JAMES A. STERLING
 Architect A I A
 142 High Street
 P.O. Box 7305
 Portland, Maine 04112
 207 772.0037
 FAX 773.8545
 chechaak@gwi.net

Re: Permit Questions
 Dated 14 September 2005

Permit # 050842

I have commenced the review of permit # 050842 and need the following to continue:

foundation detail A-A
scale: 1" = 1'-0"

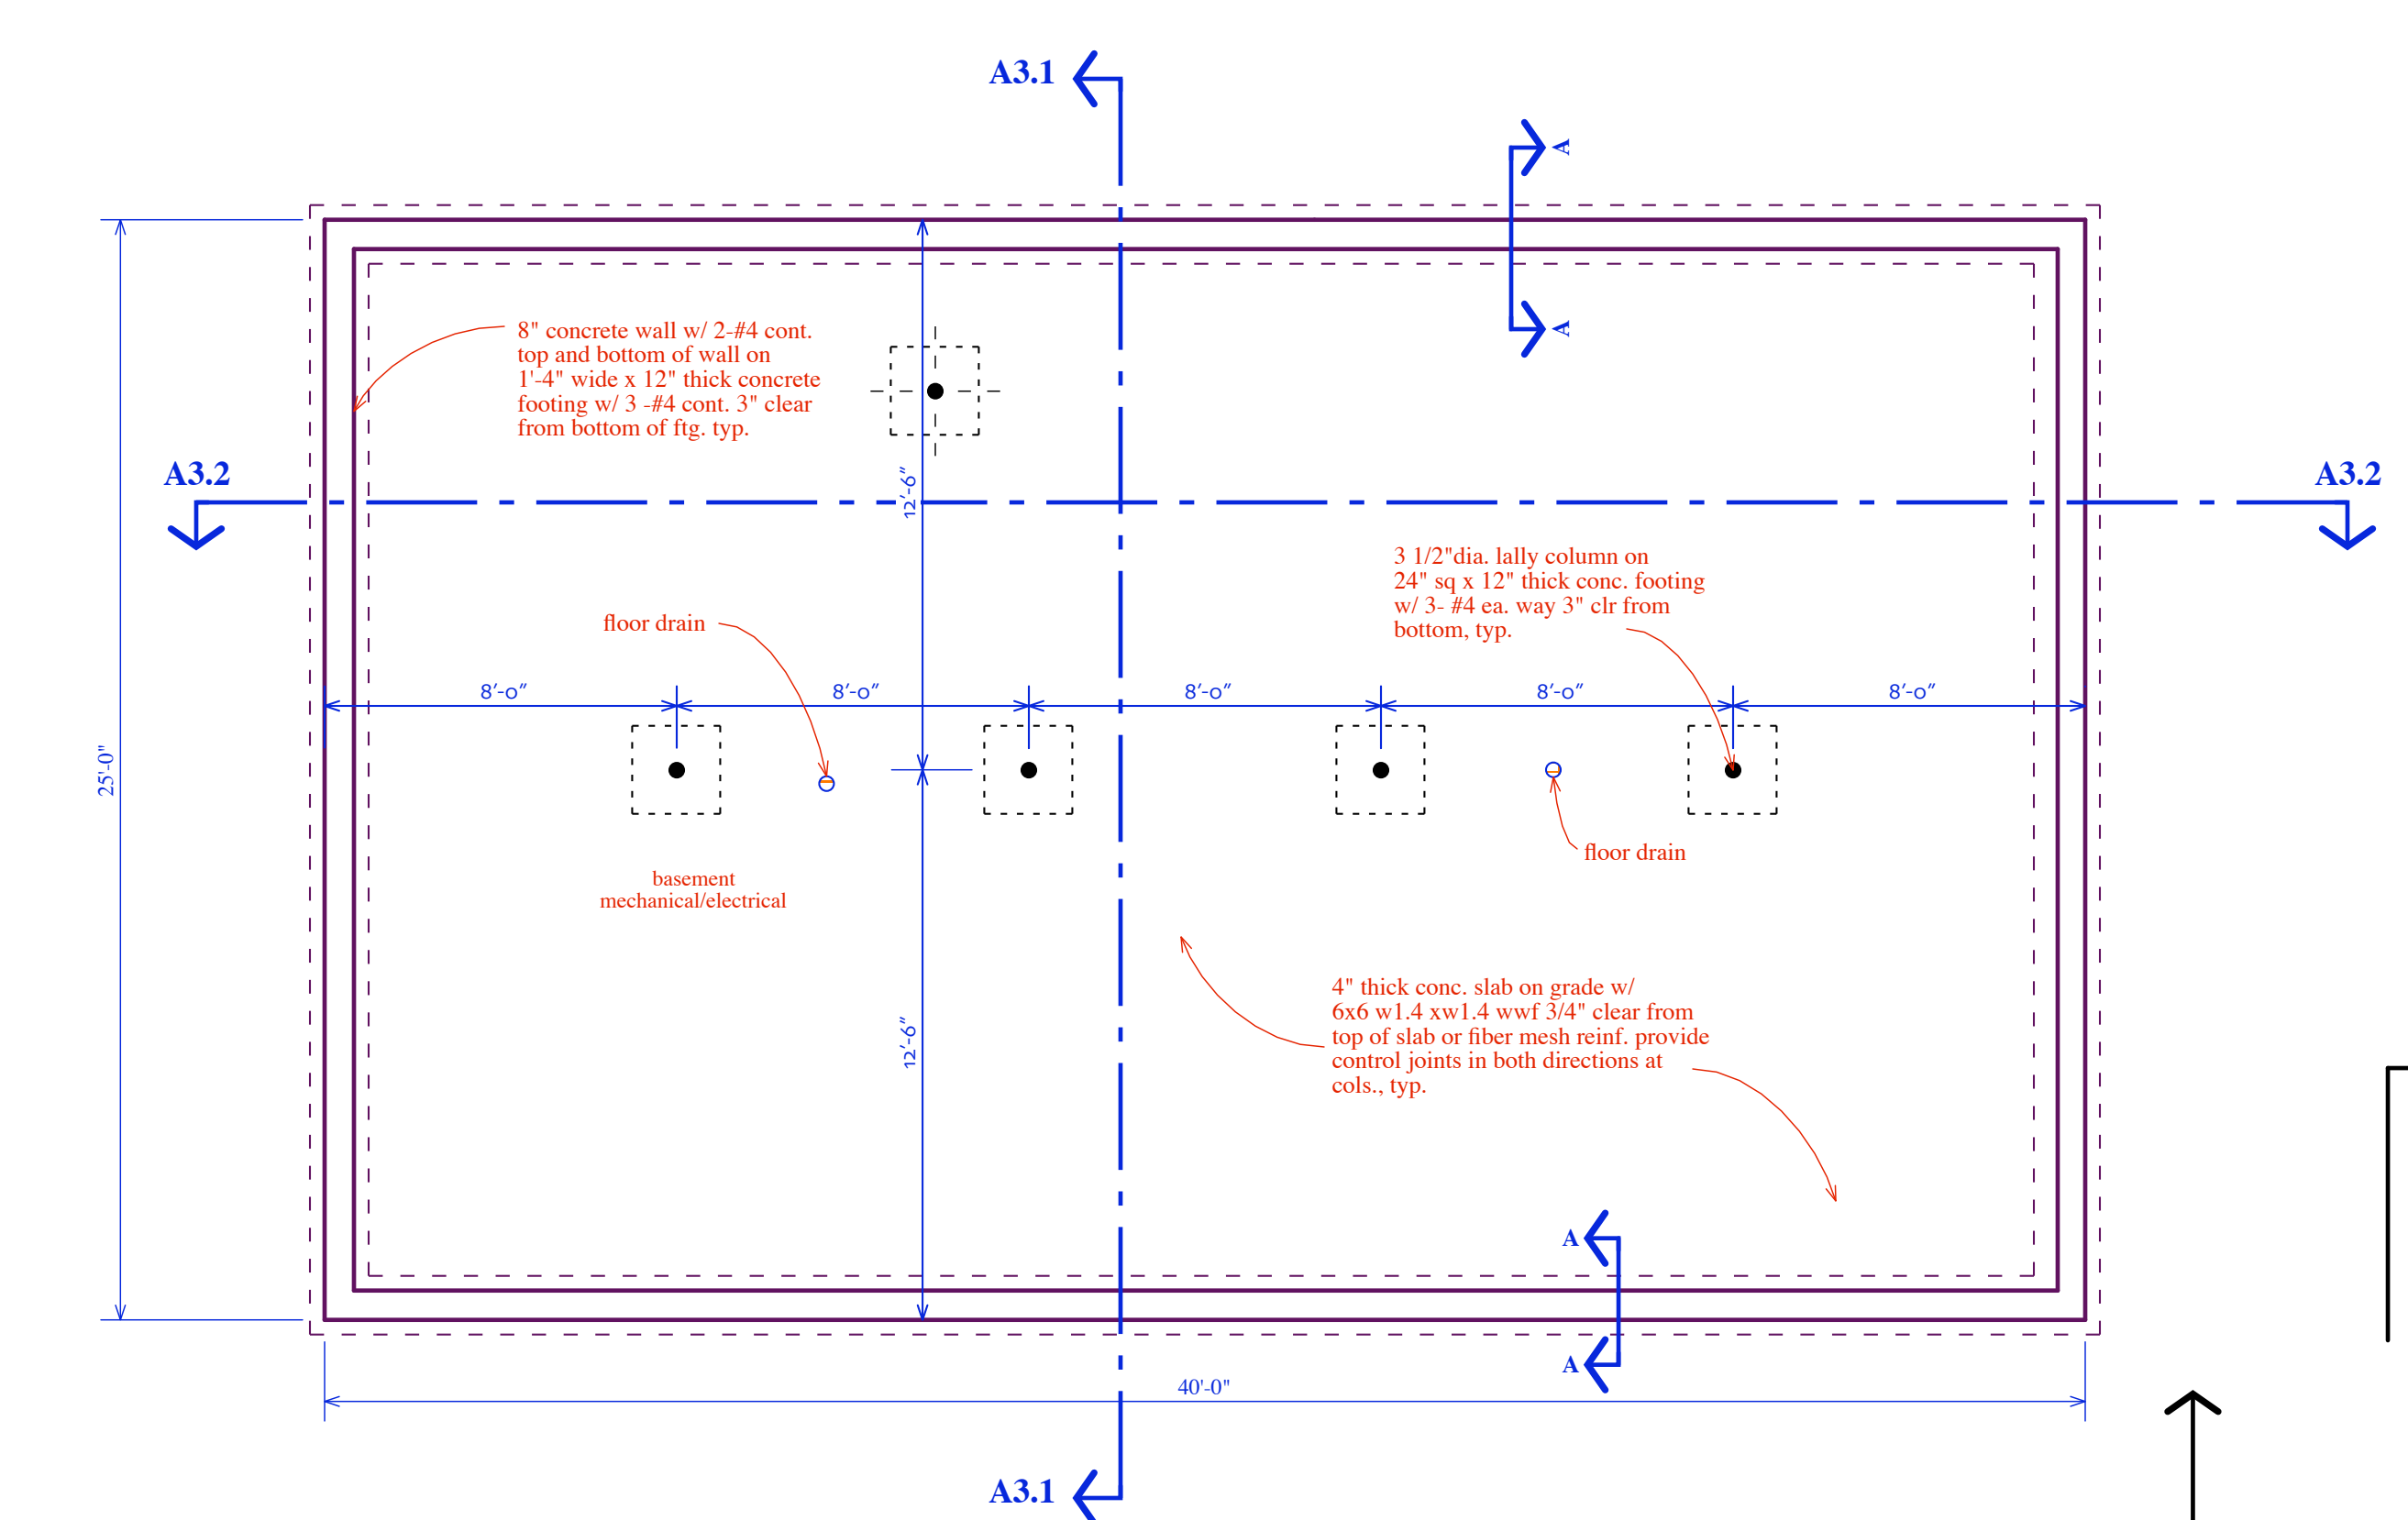
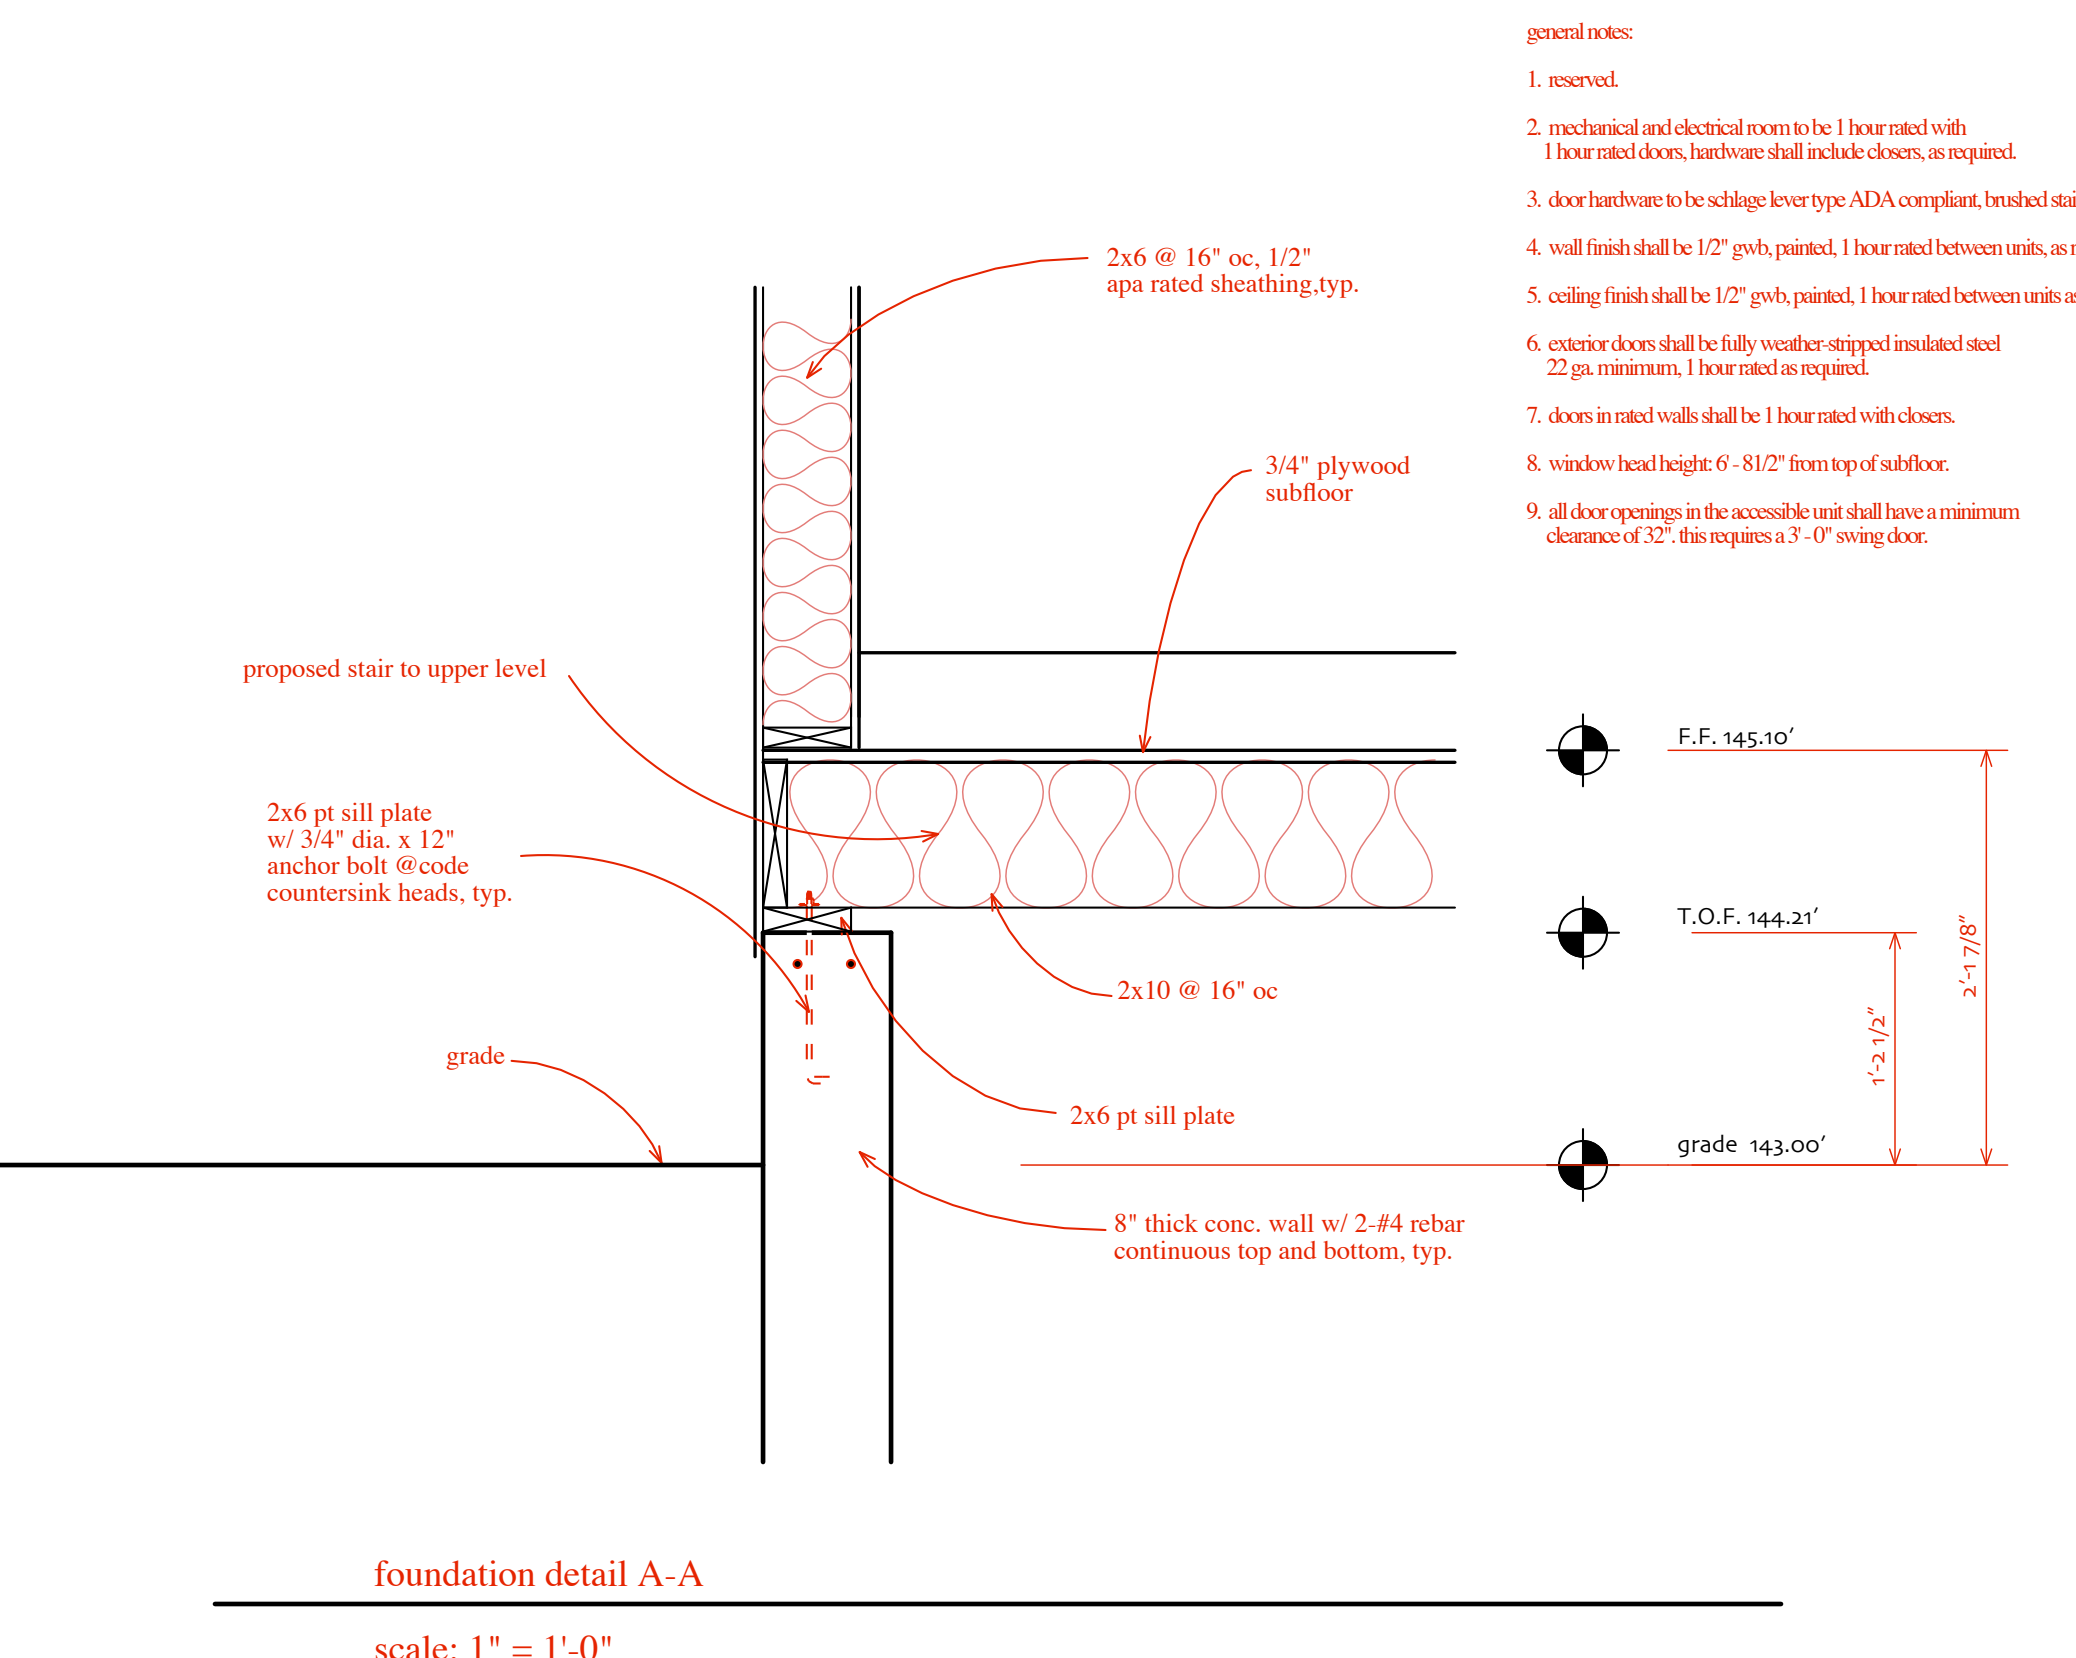
13) what is the spacing of the anchor bolts in the foundation and how far from the corners? →

SILL PLATE W/
5/8" Ø X 12" LONG
HOOKED A 307
A.B. @ 3'-0" O.
1'-0" O.
CORNERS AND
ENDS OF PLATE

8) There is no basement stair detail
